**DEVELOPMENT REVIEW BOARD
ACTION SHEET**

DEVELOPMENT REVIEW BOARD MEMO

DRB CASE NO/PROJECT NO: 1007337

RE: Tract A-2, Land of Eufelia A. Gabaldon

**PLAT OF
TRACTS A-1 AND A-2
LANDS OF EUFELIA A. GABALDON**
WITHIN
SECTION 12, TOWNSHIP 10 NORTH, RANGE 2 EAST, N.M.P.M.
CITY OF ALBUQUERQUE
BERNALILLO COUNTY, NEW MEXICO
MAY, 2008

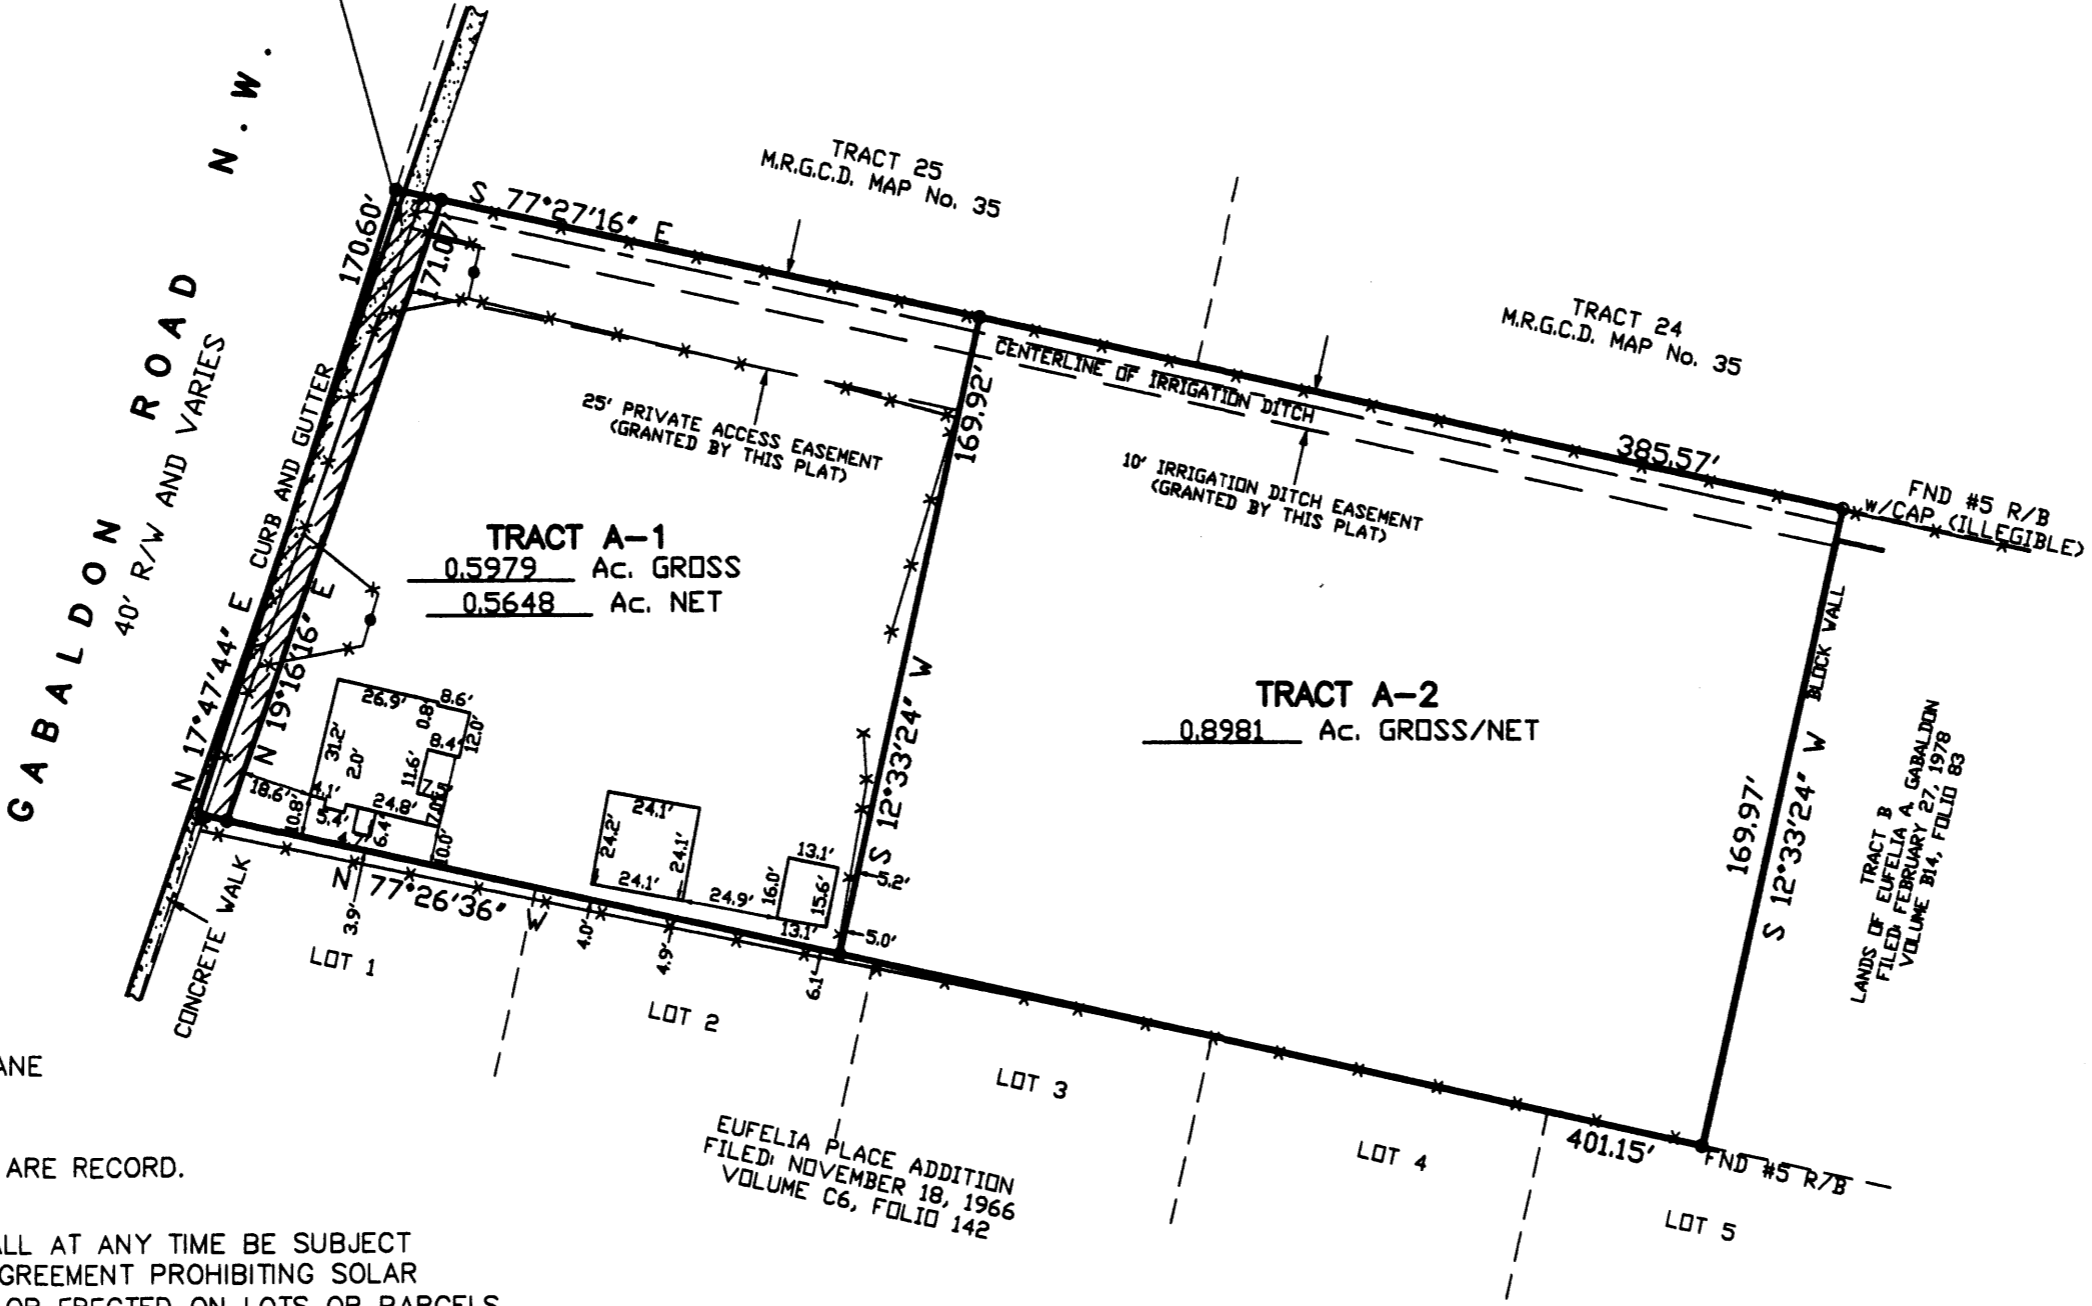
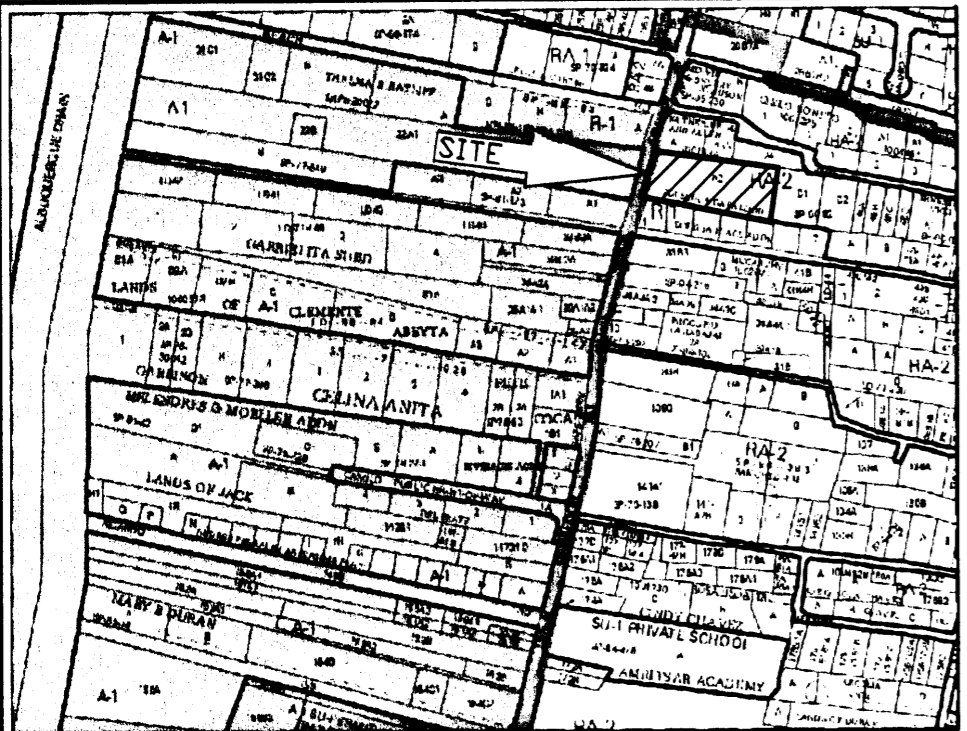
A Grading and Drainage Plan will be required.
A drainage easement may be required for the benefit of Tract A-2.

The City's Geographic Information System indicates the existing Lot designation is already A-2; new lots would need to derive from that. Free Consent statement should mention dedication of right-of-way. Maintenance and Beneficiaries of proposed easement need to be called out on plat.
